Monrill's Crossing

33 Allen Avenue

Memorandum  
Department of Planning and Development  
Planning Division

**To:** Chair Delogu and Members of the Portland Planning Board  
**From:** Sarah Hopkins, Development Review Services Manager  
**Date:** June 17, 2004  
**Re:** Planning Board Workshop June 22, 2004  
Packard Proposed Contract Zone

Exhibit B Site Plan Exhibit

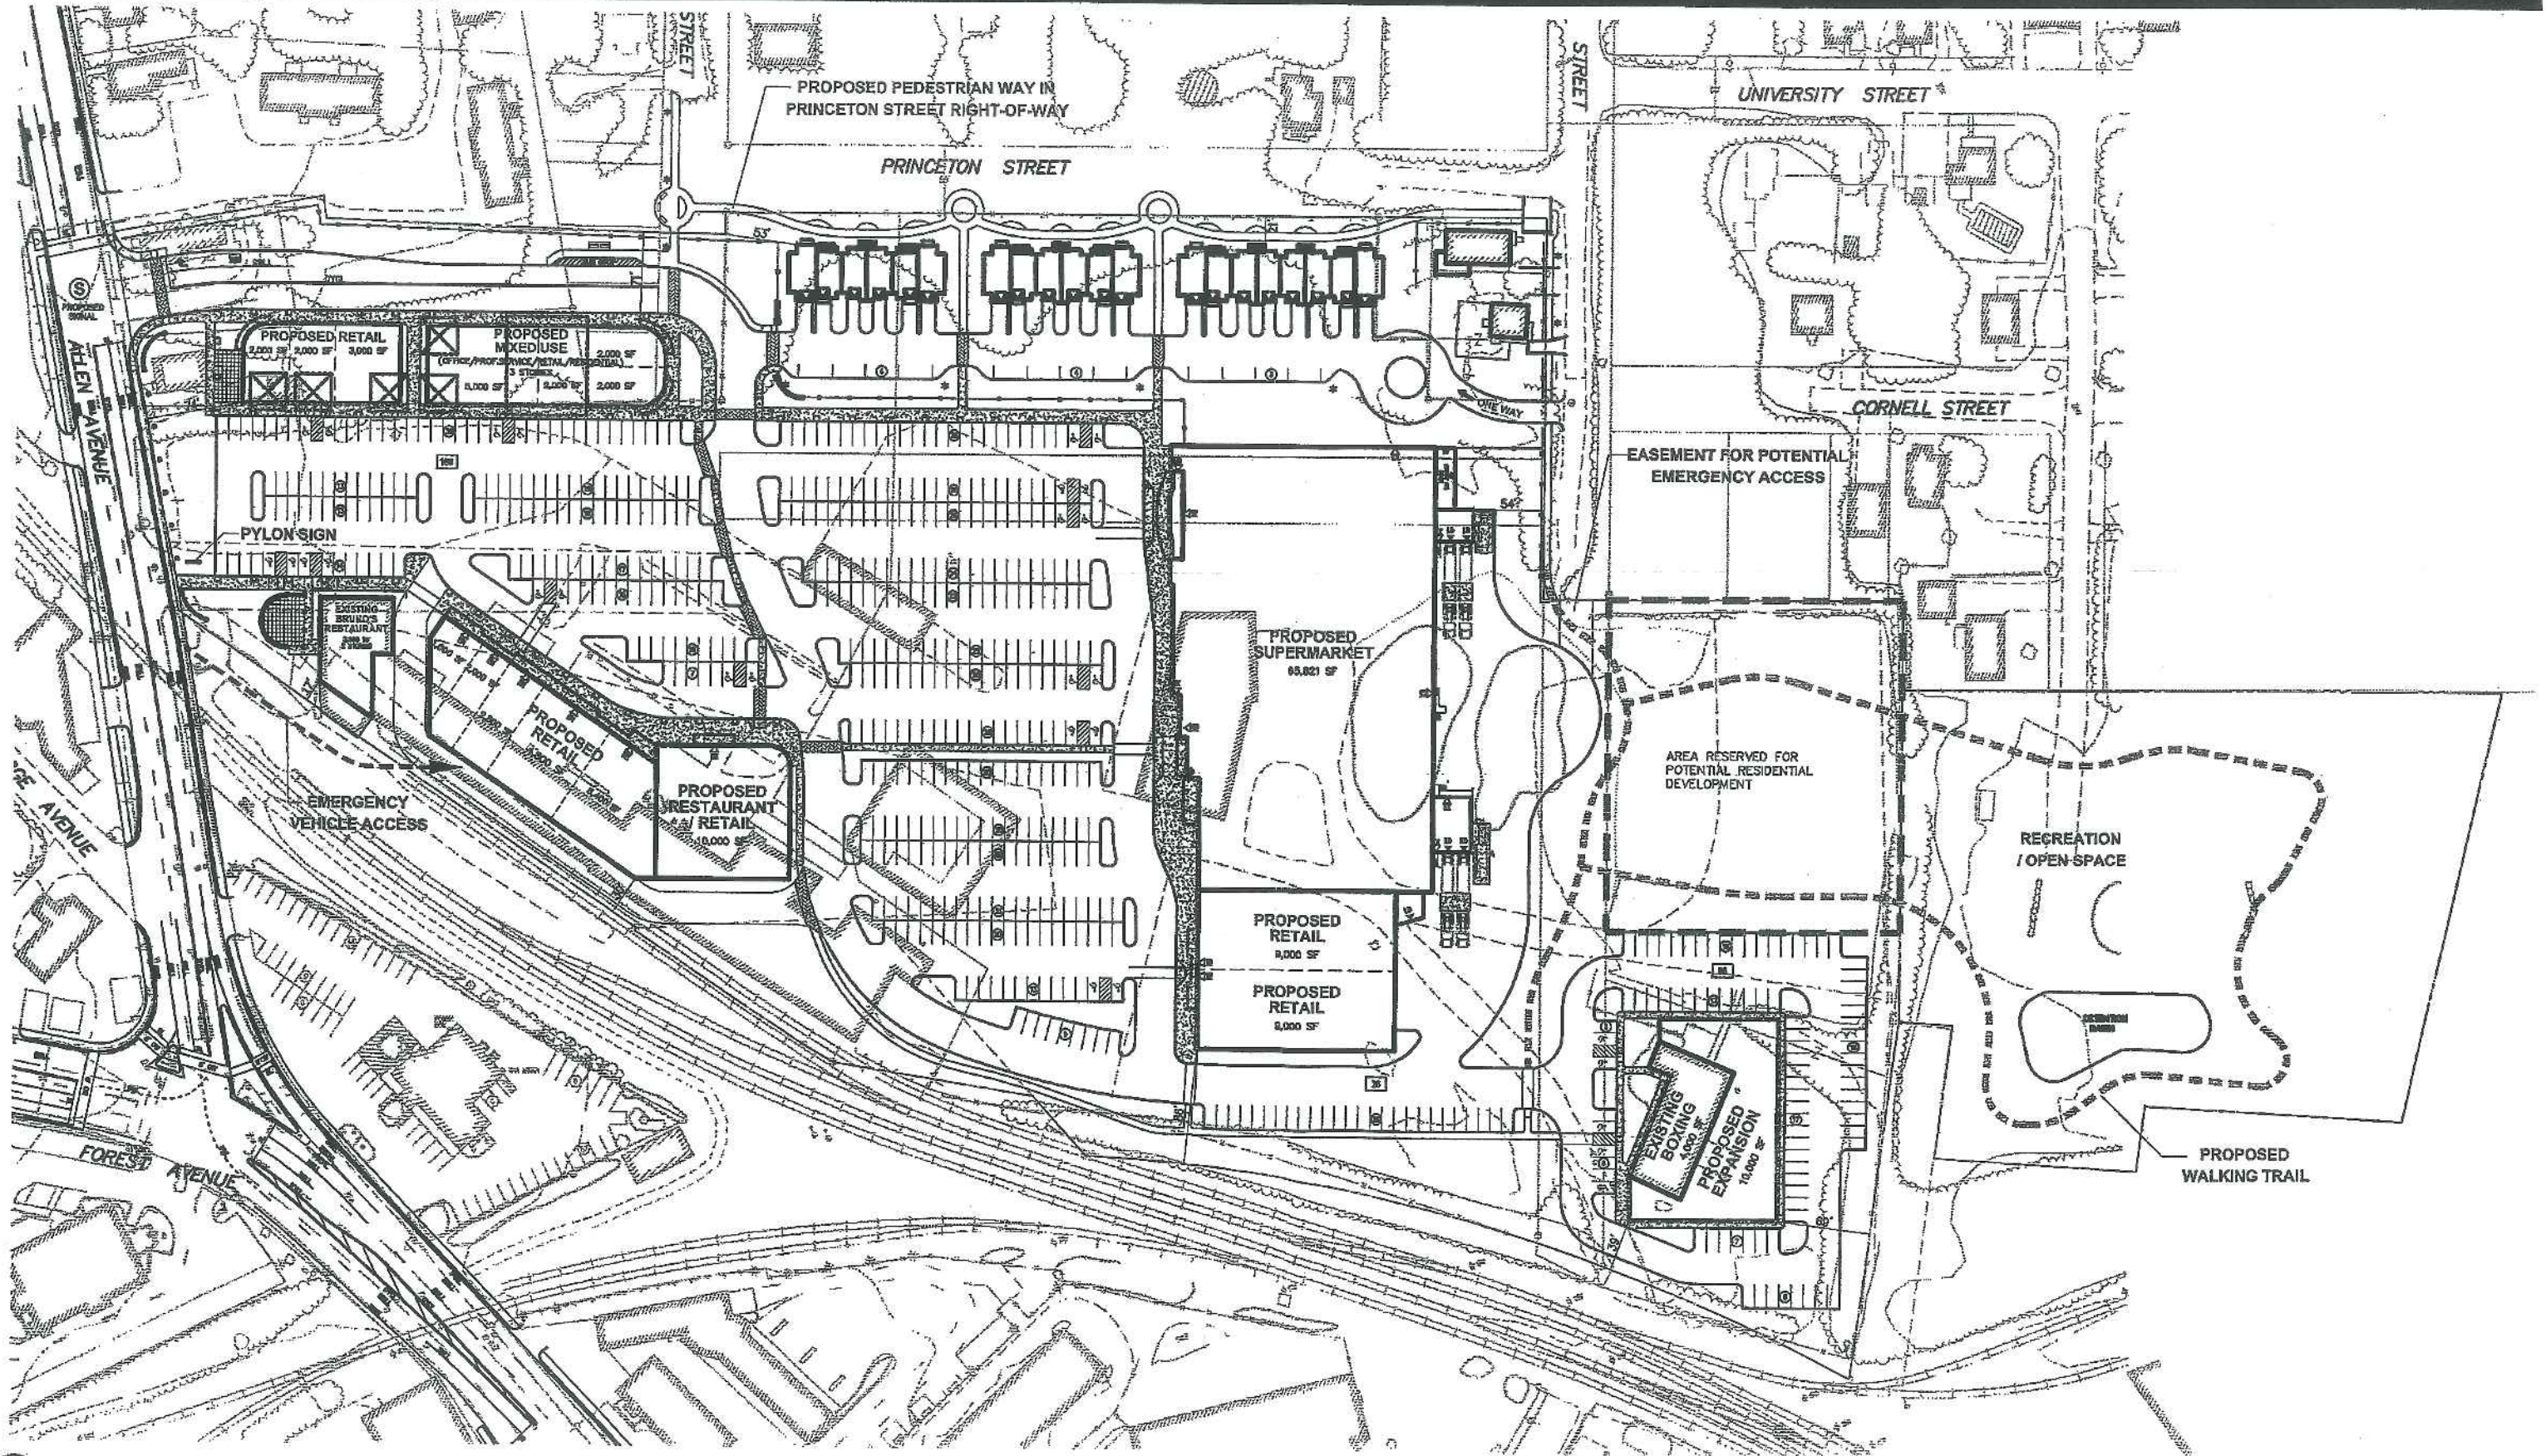
In consultation with staff from the Housing and Neighborhood Services Division, Planning staff has recommended the removal of the previously proposed multifamily apartment building to the rear of the site. Potential conflicts with loading operations and impacts, as well as the potential isolation of the residential units, provided convincing reasons for the units' removal. As such, staff has encouraged the applicant to increase the housing in the more viable areas; those being the townhouse units along Princeton Street and the upper story apartments closer to Allen Avenue.

Staff issues relate to how many apartments will fit above the retail. In the applicant's proposal, 6 apartment/work live areas are proposed above the second building in from Allen Avenue. The applicant is hesitant to create upper stories on the first building for residential use, since there is an architectural intention to have the buildings "step up" in height as one proceeds from Allen Avenue into the development.

While there are no floor plans at this time, we would suggest that the first building be increased to two stories as one approaches from Allen Ave., securing a portion of second floor area for apartments. Staff is recommending a minimum of twelve (12) to fourteen (14) dwellings be developed above the retail in the two front buildings along the entry drive. If after a reasonable period of time of availability for occupancy, any units fail to be rented, perhaps a conversion to office could be contemplated.

Since the last workshop, the applicant has added more townhouse units along Princeton Street. Again, these additional units are meant to restore some units lost through the removal of the multifamily structure to the rear of the site.

Note also, the one way access through a roundabout from Morrill Street. Such an access will provide for limited, calmed access to the shopping center and townhouses from the residential neighborhood, while prohibiting access to the neighborhood from the shopping center.

Staff has reservations about the construction of the affordable housing units to the rear of the site. The units would be isolated from the neighborhood and out of sight. The location of the housing units to the rear of the loading raises additional questions regarding compatibility and income disparity. If the site design and access problems are resolved (with residential access from Cambridge Street rather than through the shopping center), the rear units could be more viable.

Also, if the apartments are to be constructed in the future, under which zoning density, setbacks and parking requirements should they be developed? The surrounding neighborhood is R-5, but the density of the housing development appears to be more of an R-6 or R-7 density.

Exhibit C Off-Site Improvements

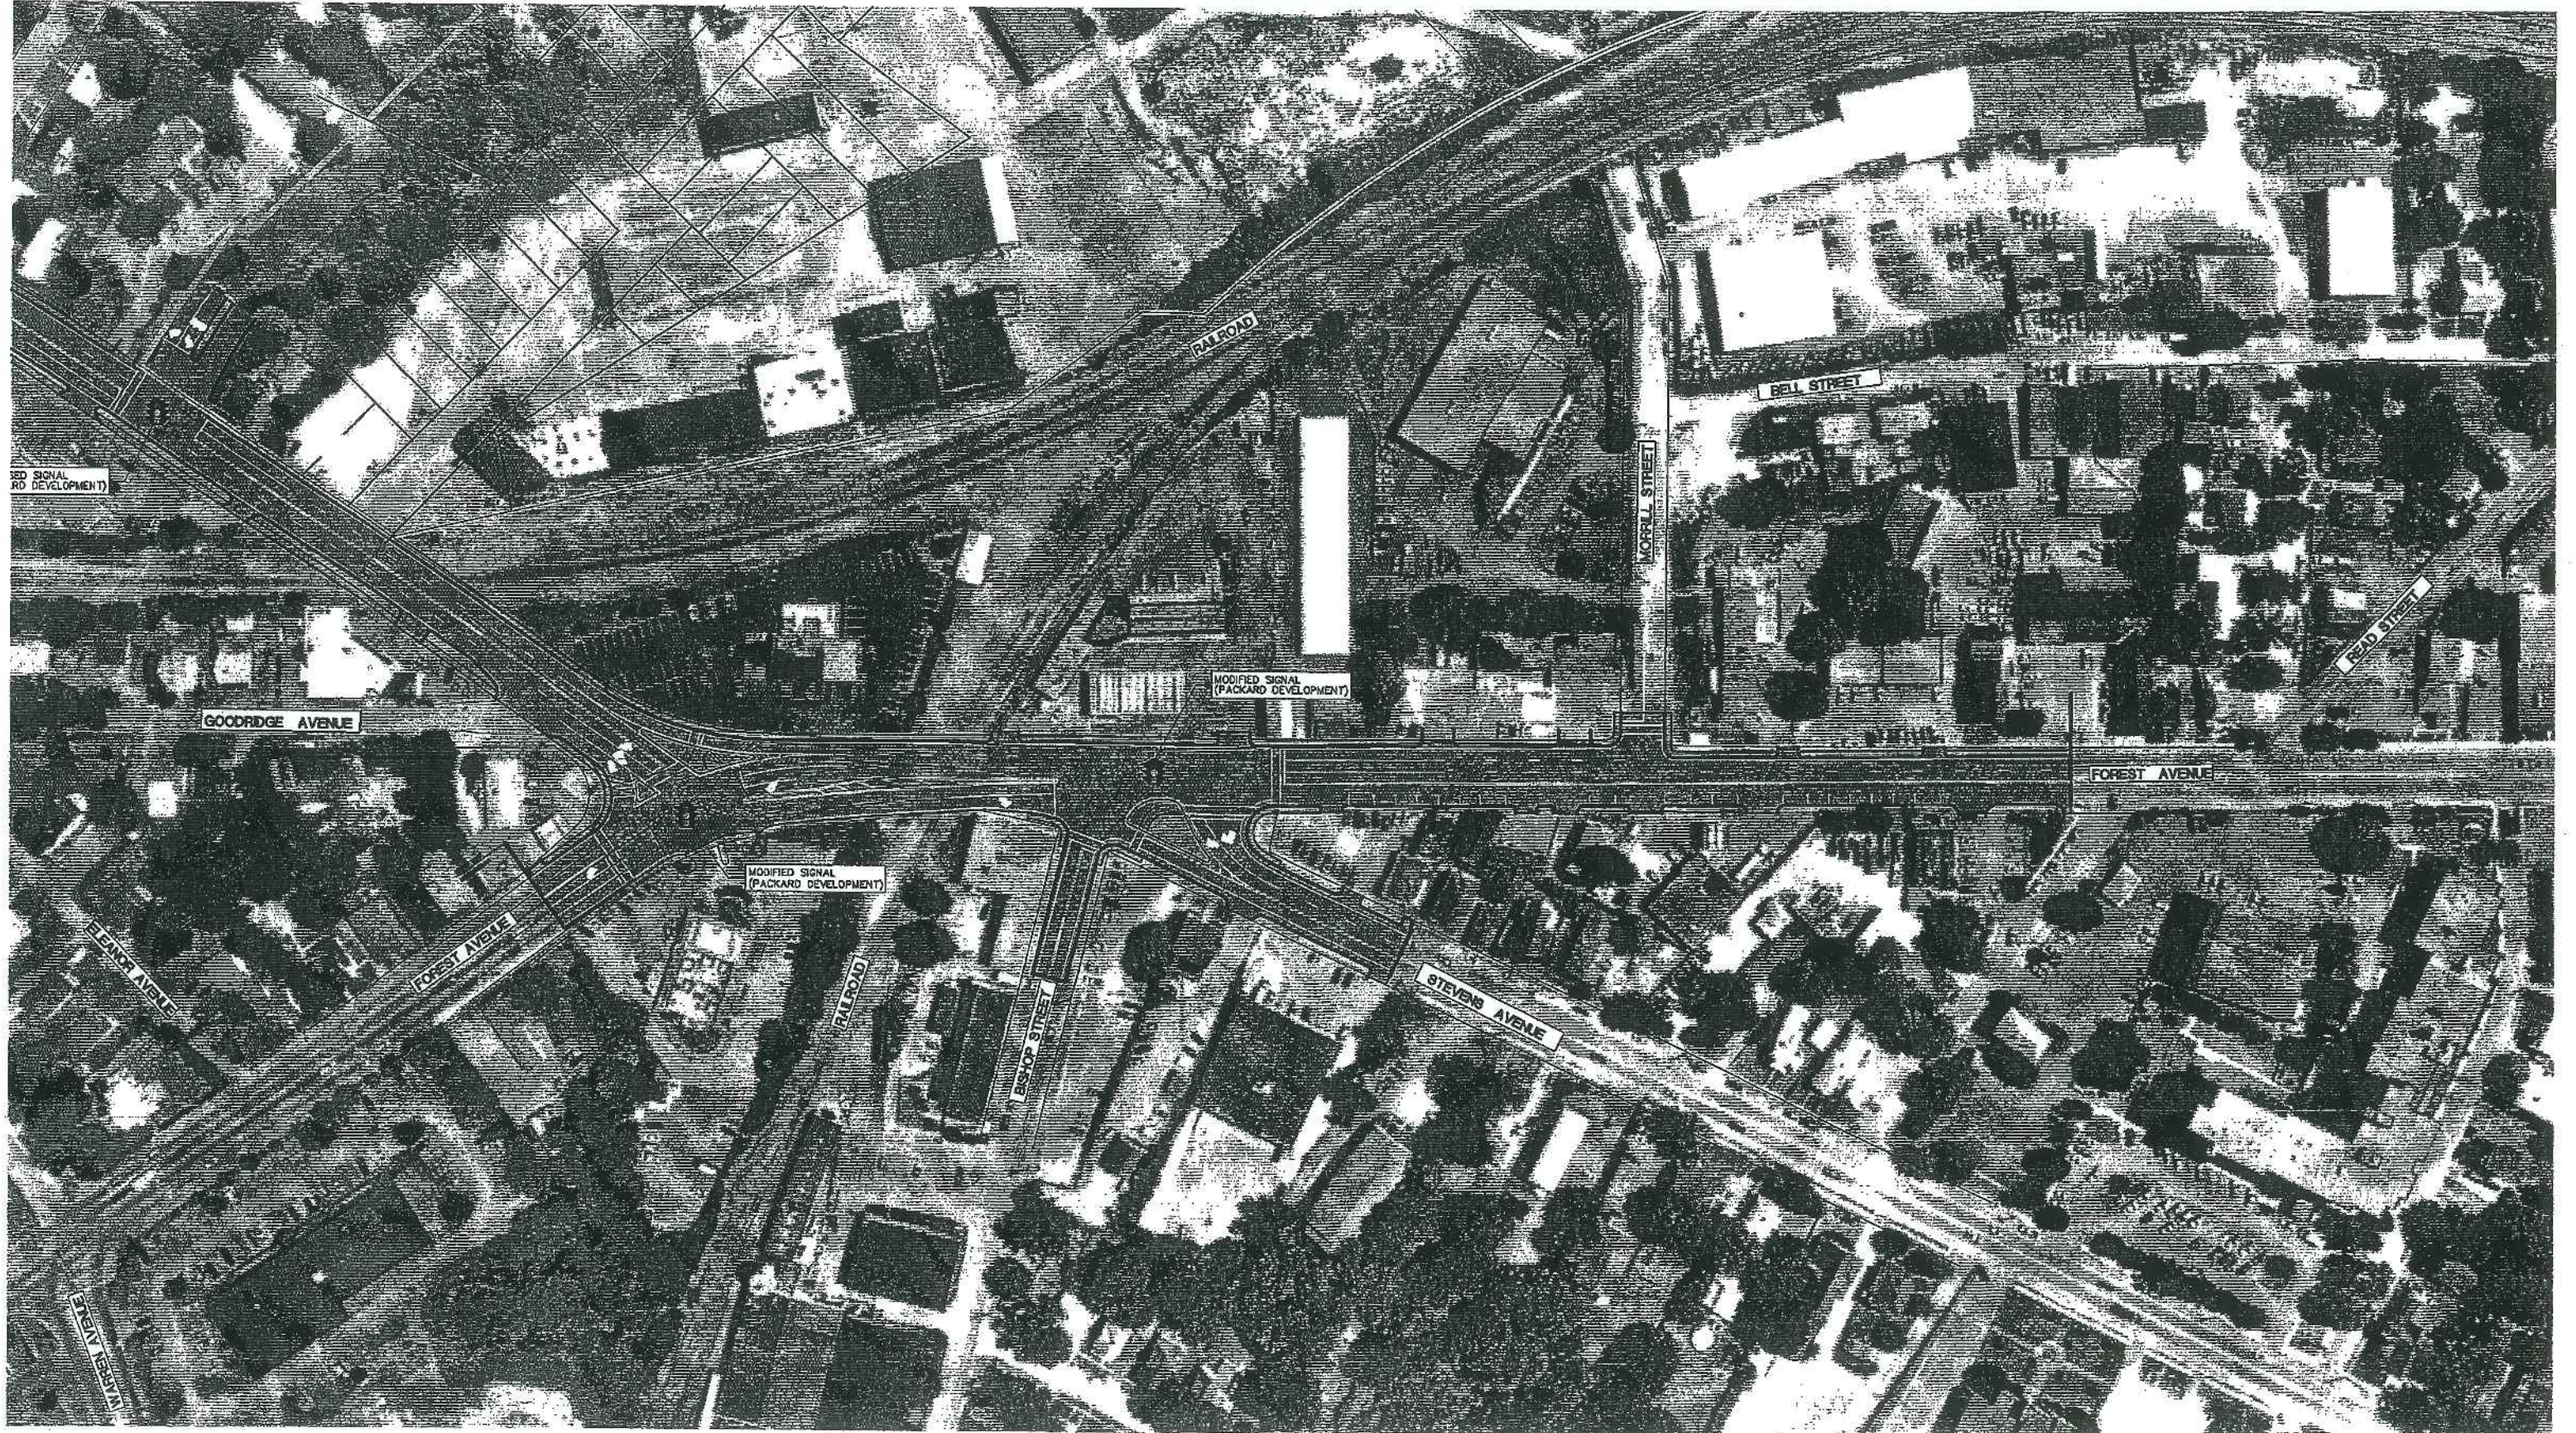
The applicant is working on a detailed plan of the Morrill's Corner traffic improvements. These improvements will be constructed as part of Phase I.

Staff and the applicant are in agreement with this condition; however, the possibility and location of future bike lanes is still in question.

SIGN SUMMARY	
STOP & SHOP SIGN	42.9 SF
TENANT SIGN PANELS	37.9 SF
TOTAL SIGN AREA	80.8 SF

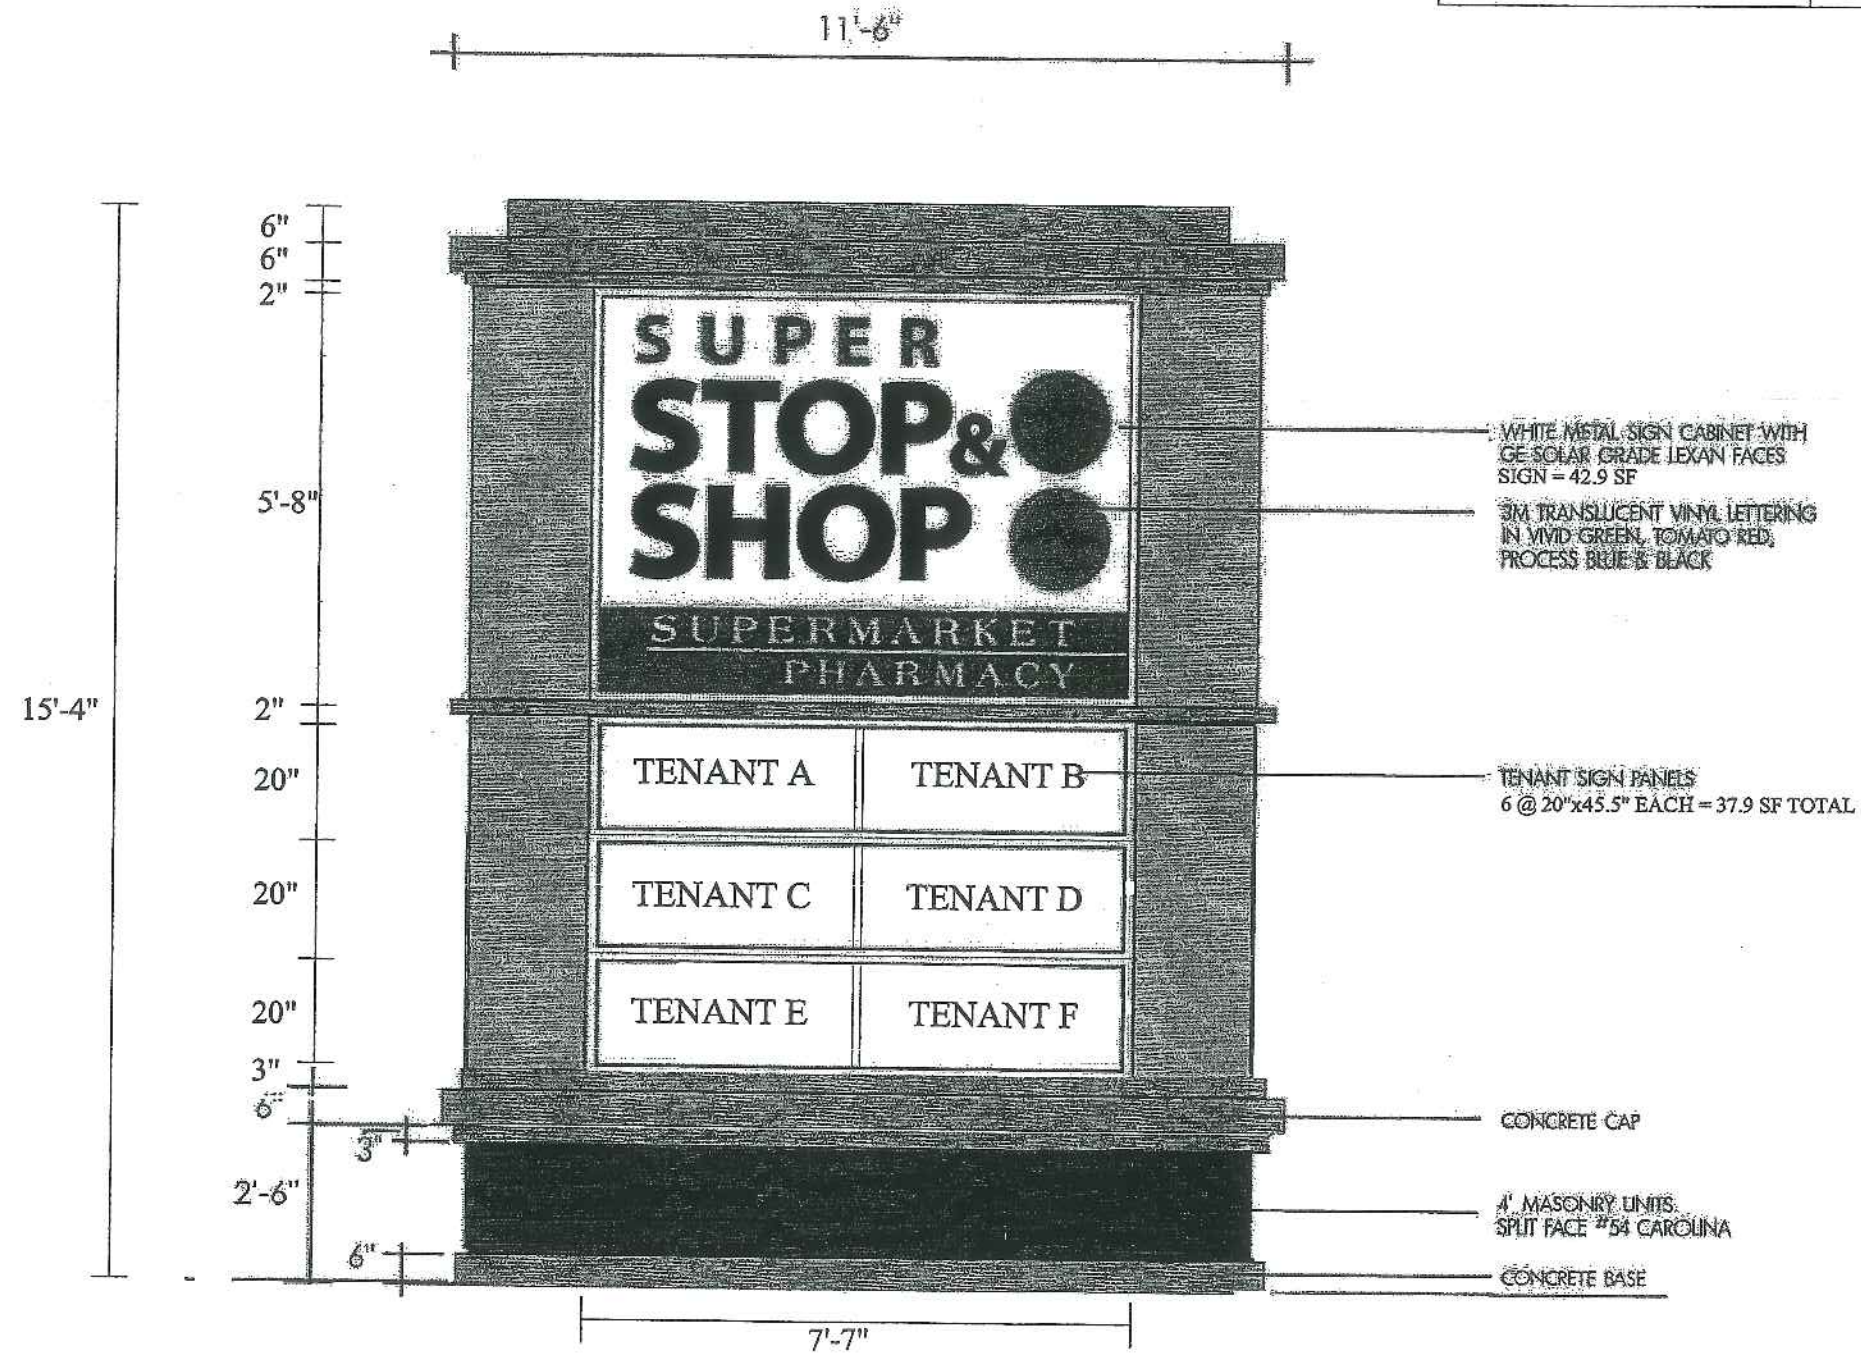
A schematic sign is included as Exhibit D of the contract. All signage will be subject to the sign ordinance related to signage in the B-2 zone. There is an provision clause in the Site Plan Ordinance that allows exceptions for certain signs.
